**EL PASO COUNTY PLANNING AND
 COMMUNITY DEVELOPMENT
 DEPARTMENT**

GRADING AND EROSION CONTROL PLAN CHECKLIST

Revised: July 2019

RETREAT AT TIMBERRIDGE FILING NO. 1 CONSTRUCTION PLANS
 GRADING & EROSION CONTROL PLAN

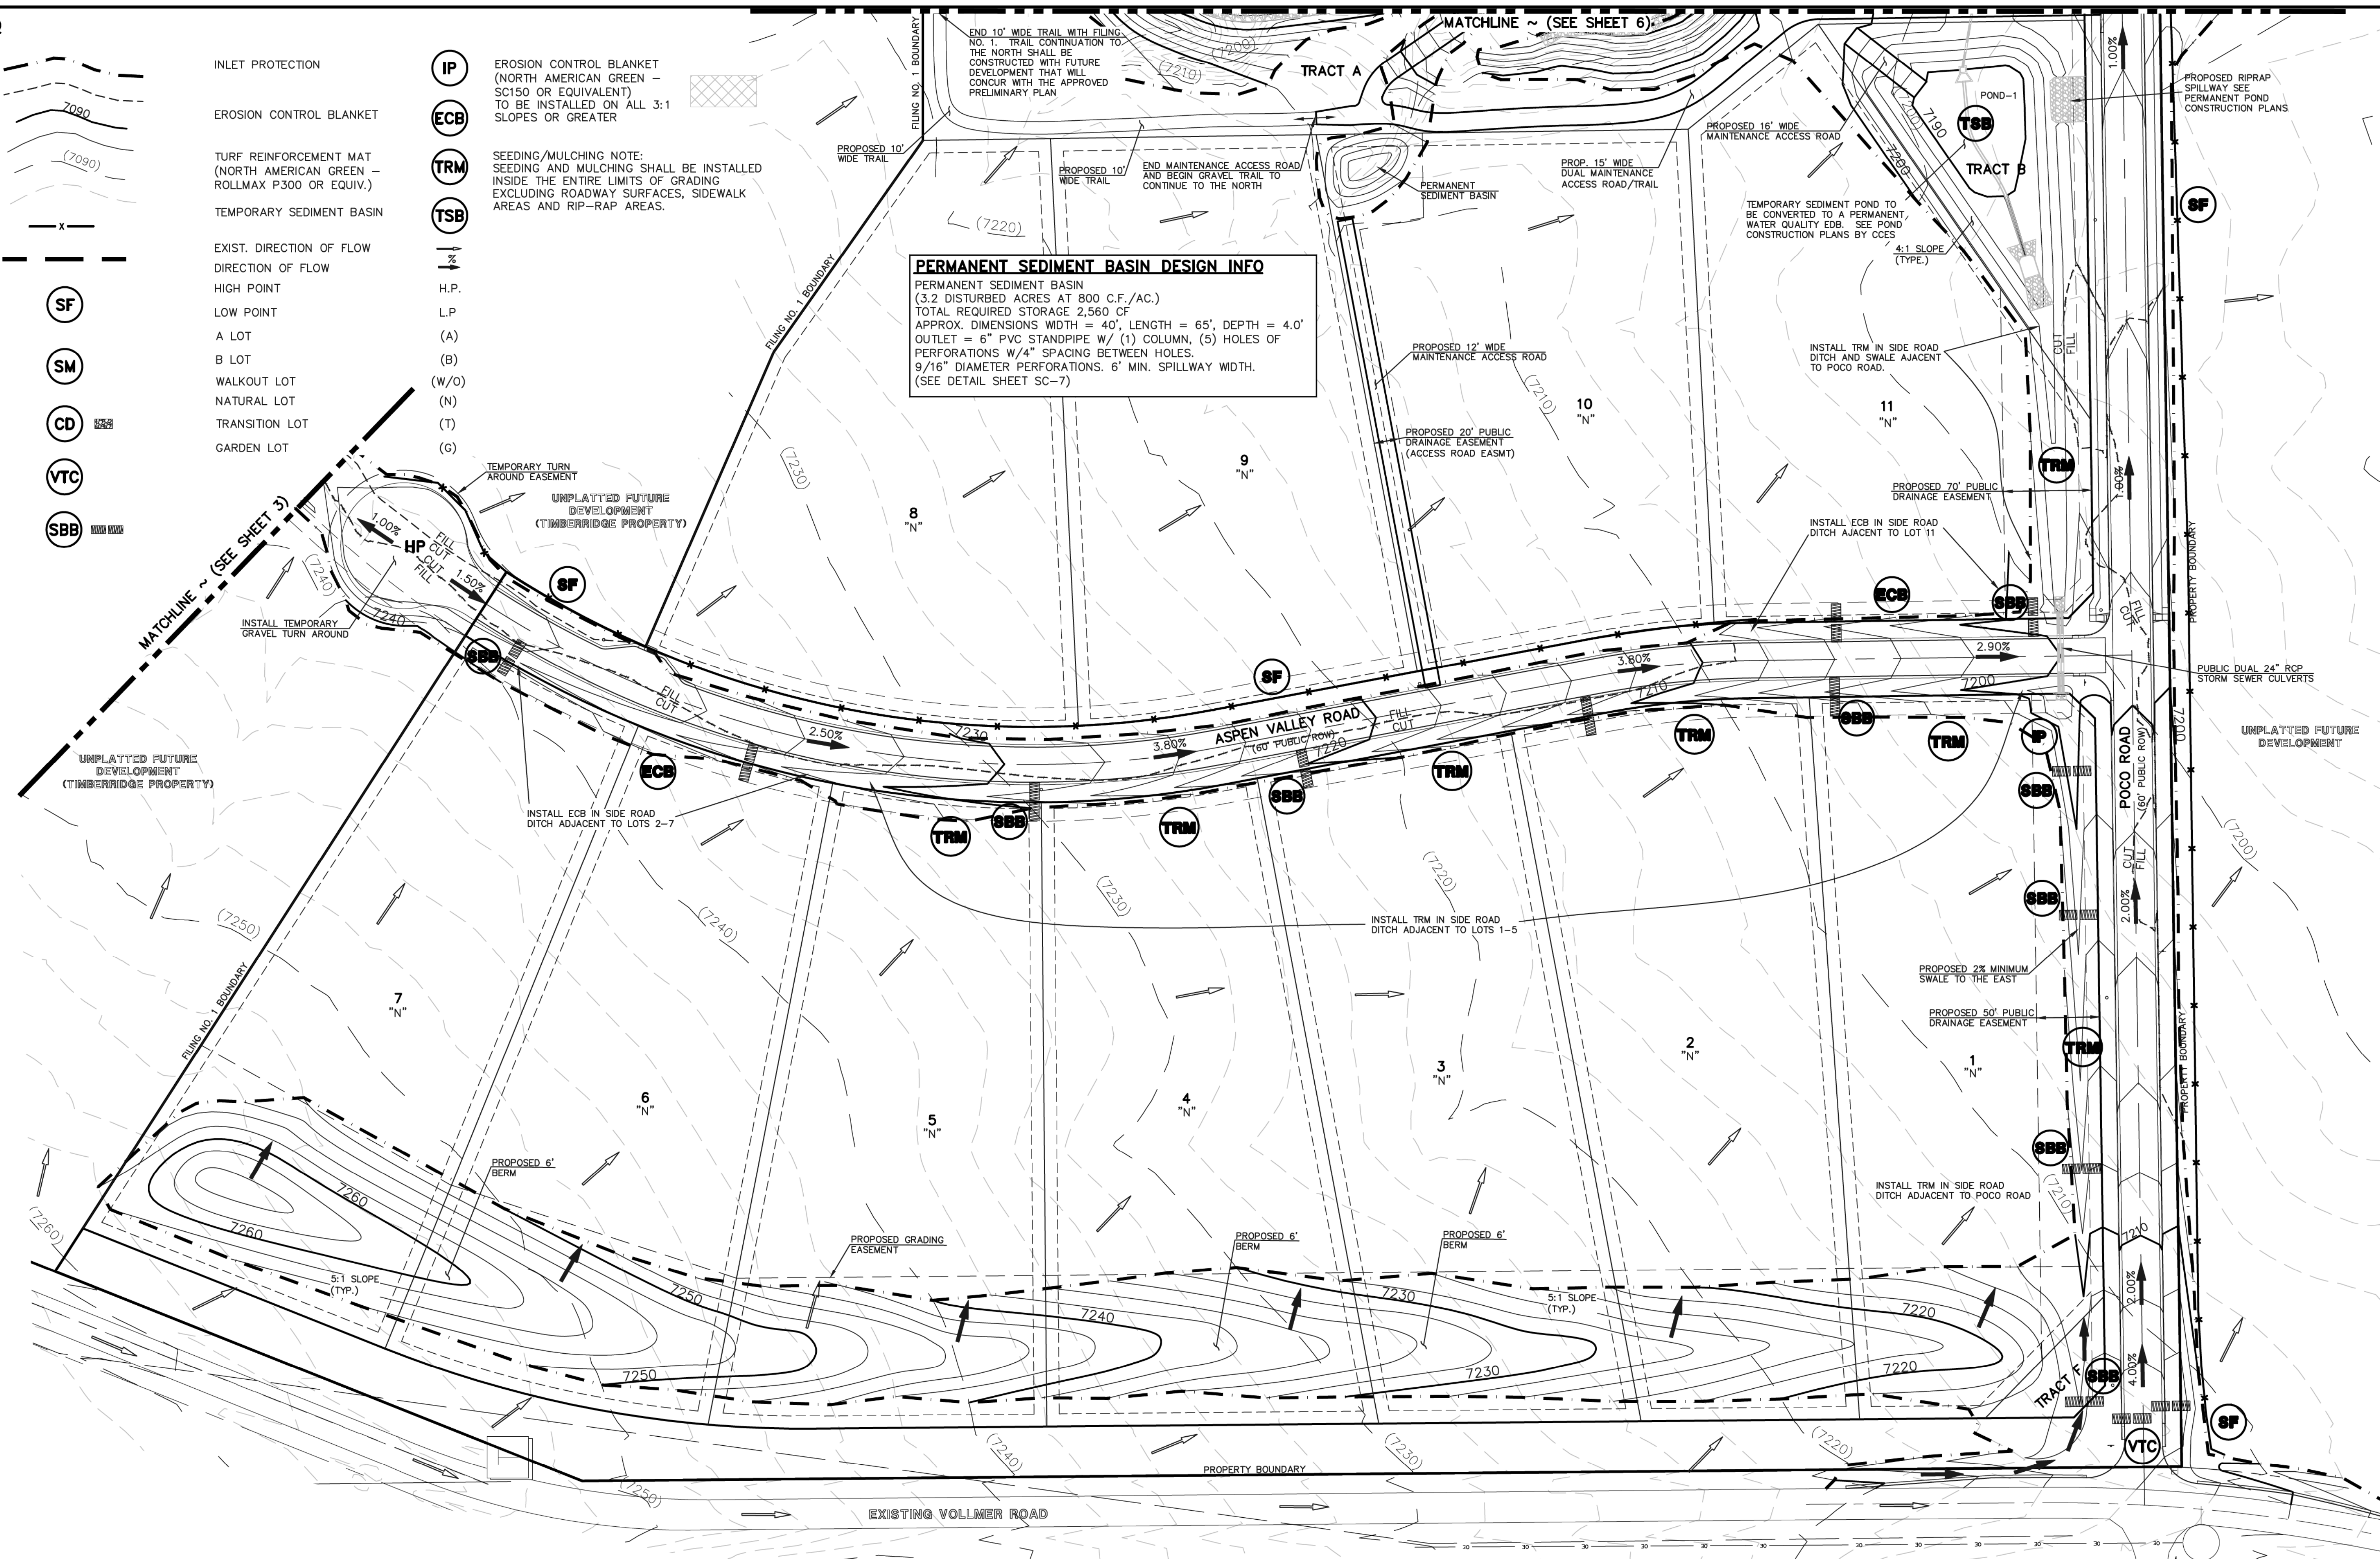
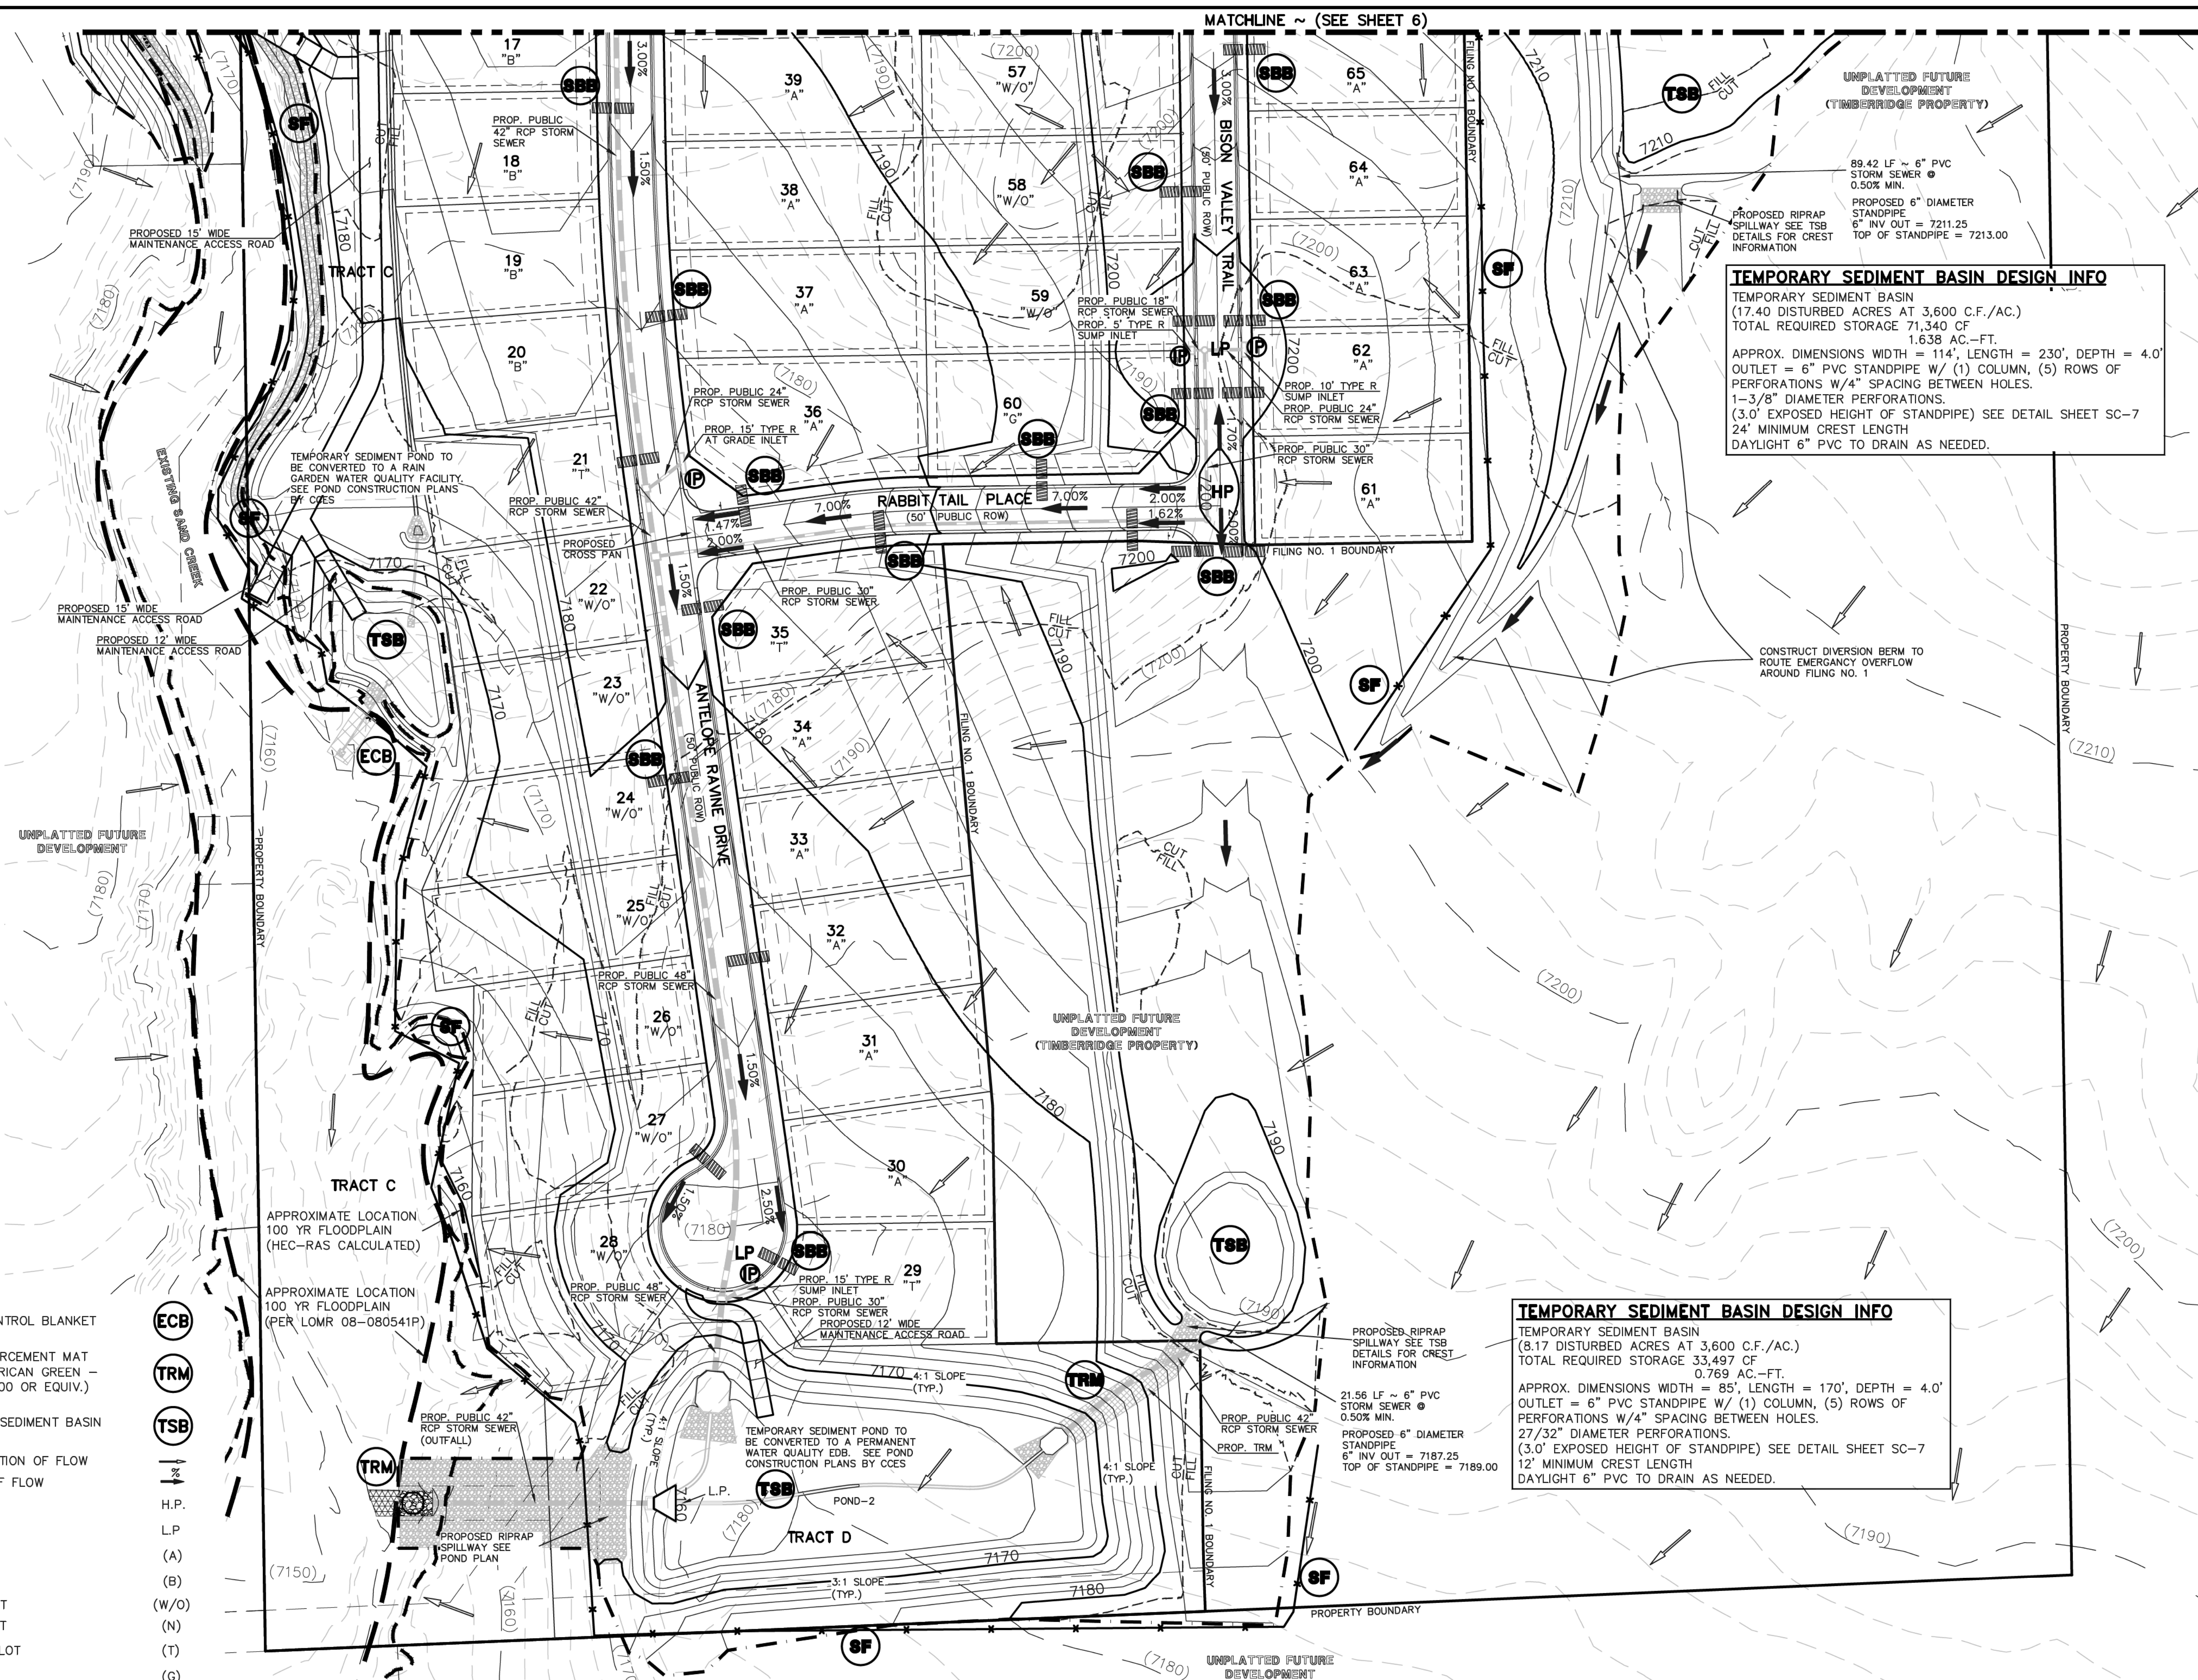
v	All proposed temporary construction control measures, structural and non-structural. Temporary construction control measures shall be identified by phase of implementation to include "initial," "interim," and "final" or shown on separate phased maps identifying each phase.	X	✗
w	Vehicle tracking provided at all construction entrances/exits. Construction fencing, barricades, and/or signage provided at access points not to be used for construction.	X	✓
x	Temporary sediment ponds provided for disturbed drainage areas greater than 1 acre.	X	✓
y	Dewatering operations to include locations of diversion, pump and discharge(s) as anticipated at time of design.	X	✗
z	All proposed temporary construction control measure details. Custom or other jurisdiction's details used must meet or exceed EPC standards.	X	✓

update notes on plan
